### **East Anglia One North and East Anglia Two Offshore Wind Farms**

**Planning Inspectorate Reference: EA1N – EN010077 &  
EA2 – EN010078**

**Deadline 7 – 4 March 2021**

**East Suffolk Council's Response to Deadline 7**

### Bat Roost and Commuting/Foraging Habitat Results

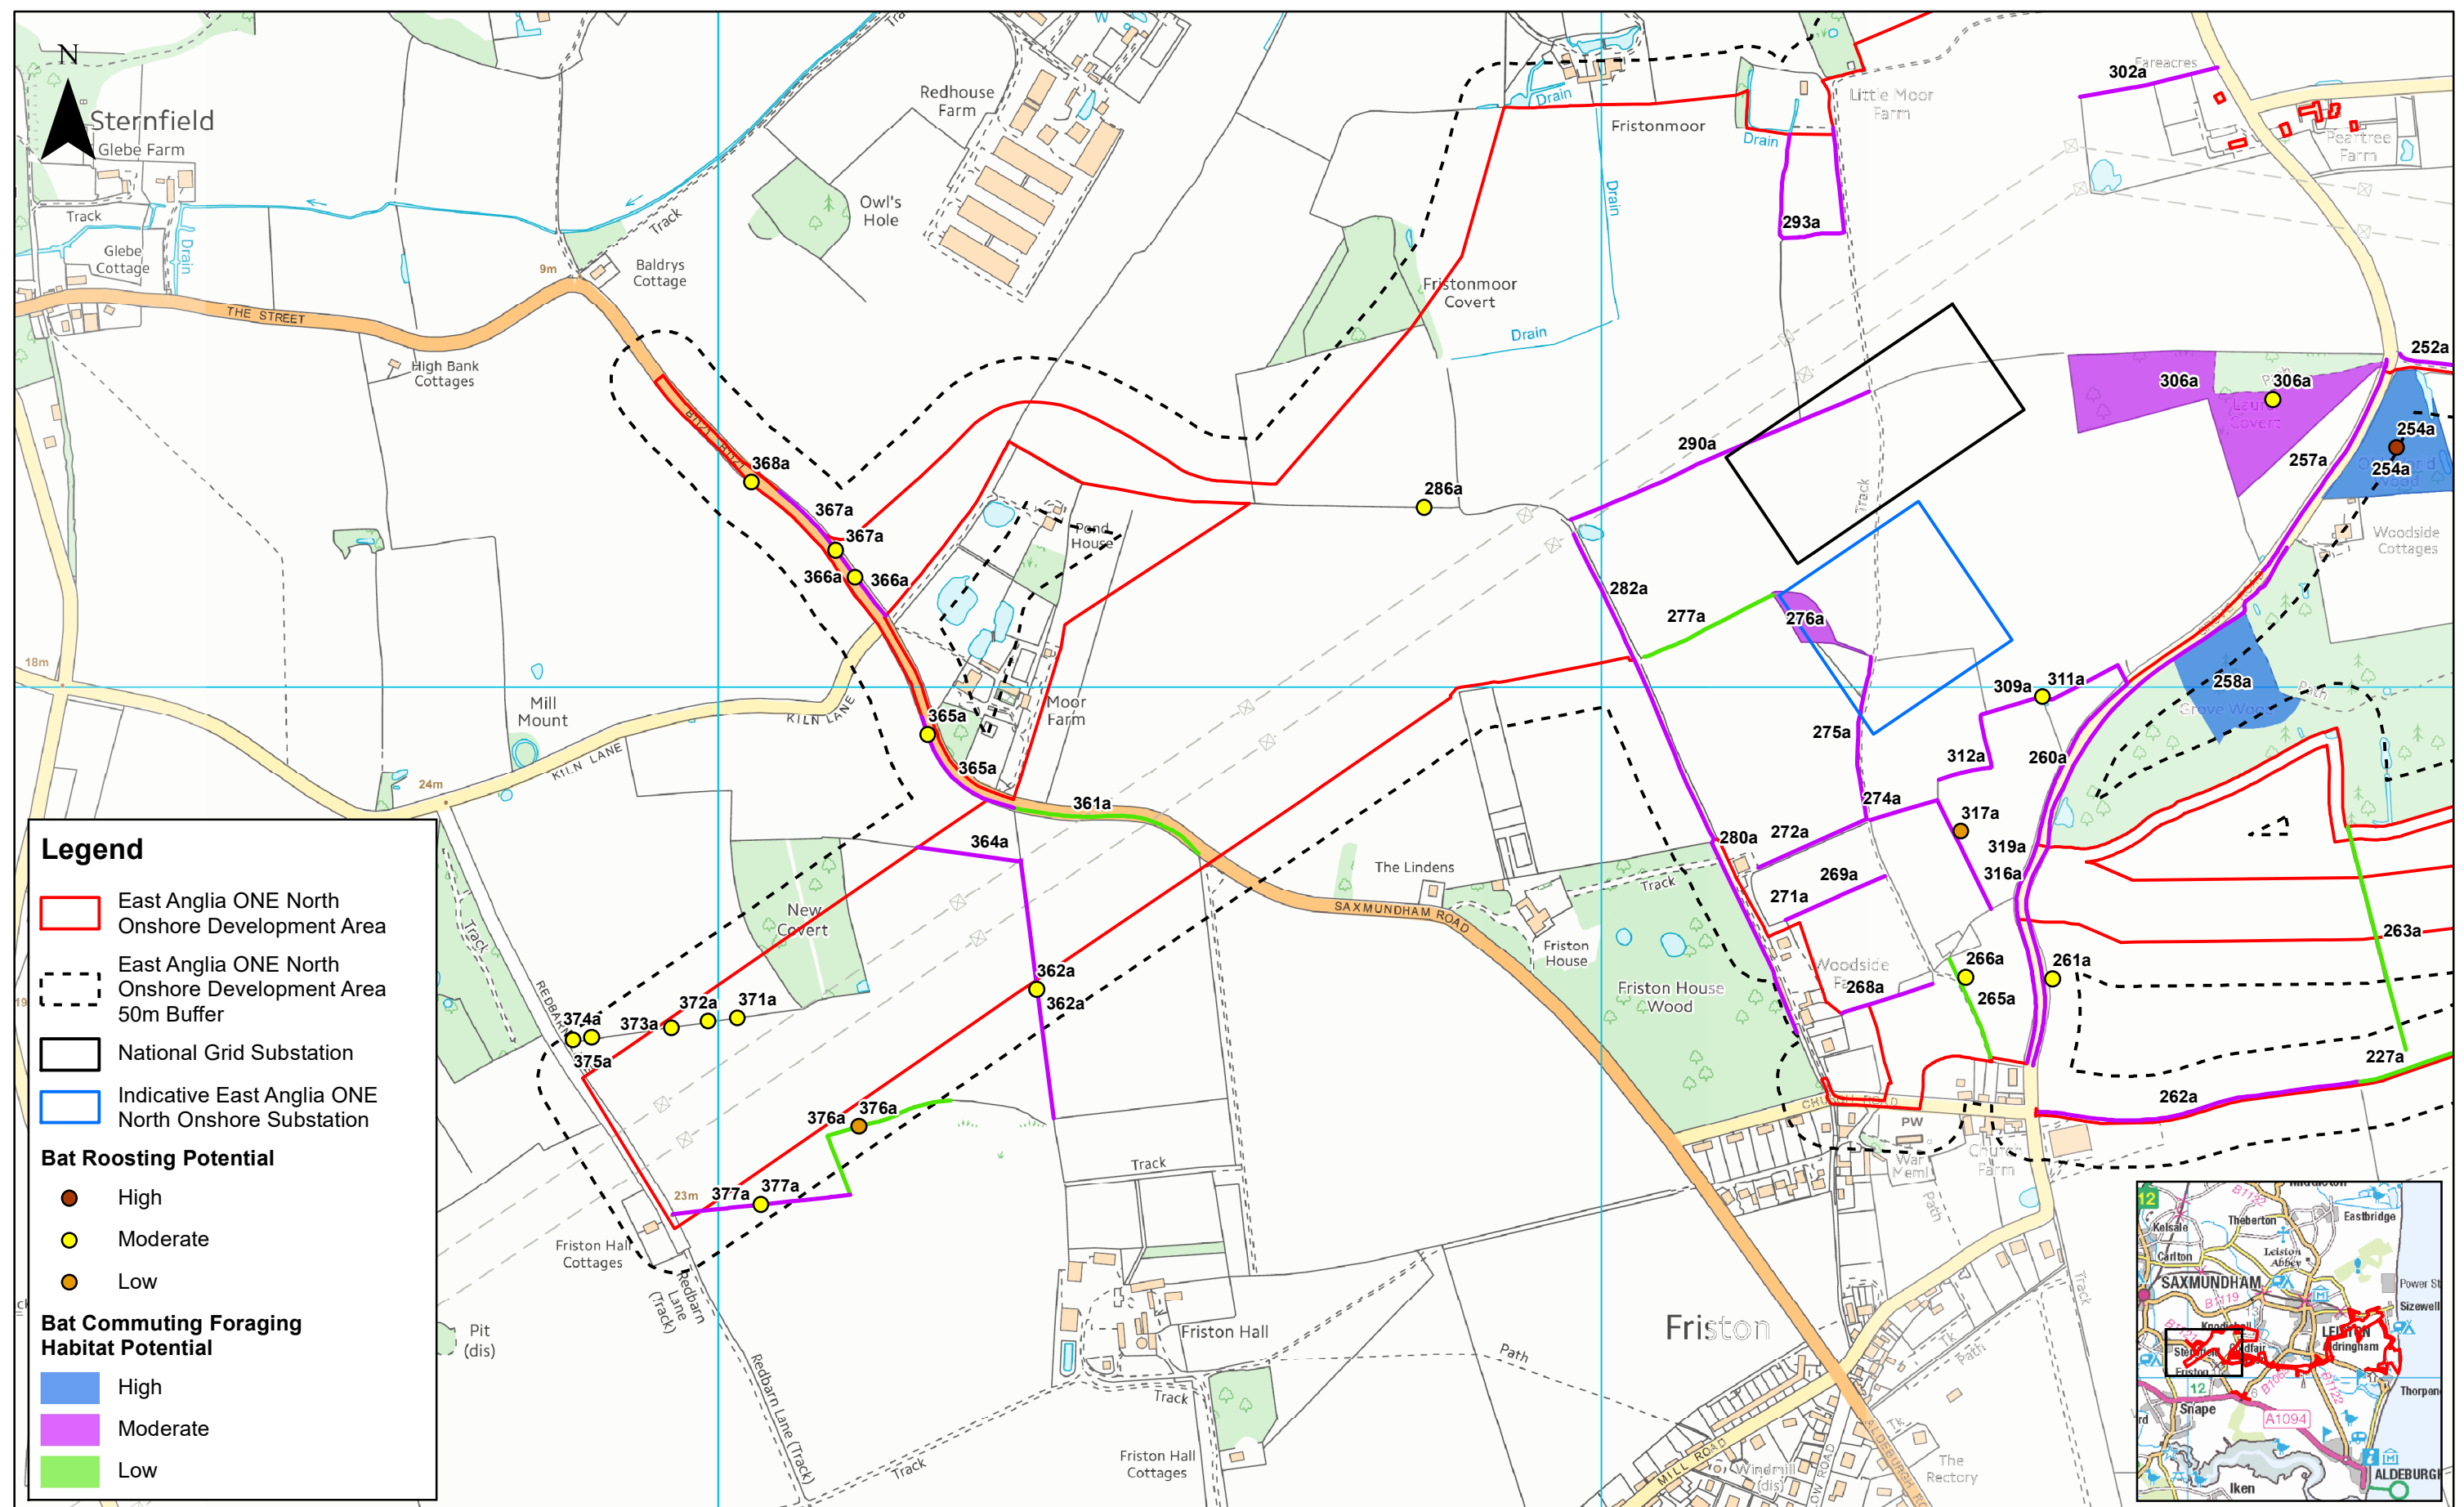
- 2.16. Bats - Whilst the Applicants' response to ESC's Deadline 5 comment (REP5-048) on this matter is noted (Section 2.3, ID1, REP6-026), the Council maintains the opinion that the absence of brown long-eared bats from the survey results is likely an under recording of this species in the area rather than a complete absence of the species. All of the bat survey techniques used (emergence/re-entry, activity transects and static bat detector) rely primarily on acoustic recording and the nature of brown long-eared bat behaviour (particularly the absence of echolocating or very quiet echolocating) is an acknowledged limitation of this type of surveying. Further comment on this matter was made at Issue Specific Hearing 7 (ISH7, REP6-075).

2.17. We also note the comment in the relation to maternity bat roosts being present at other substation sites (Section 2.3, ID2, REP6-026). As set out in our Deadline 5 response (REP5-048), and acknowledged in the Applicants' comments on this matter, different bats are affected by noise to different degrees and the presence of a maternity colony of one species in such a location does not mean that all other species have not been affected. Further information on the species present roosting within existing substations would have been beneficial.
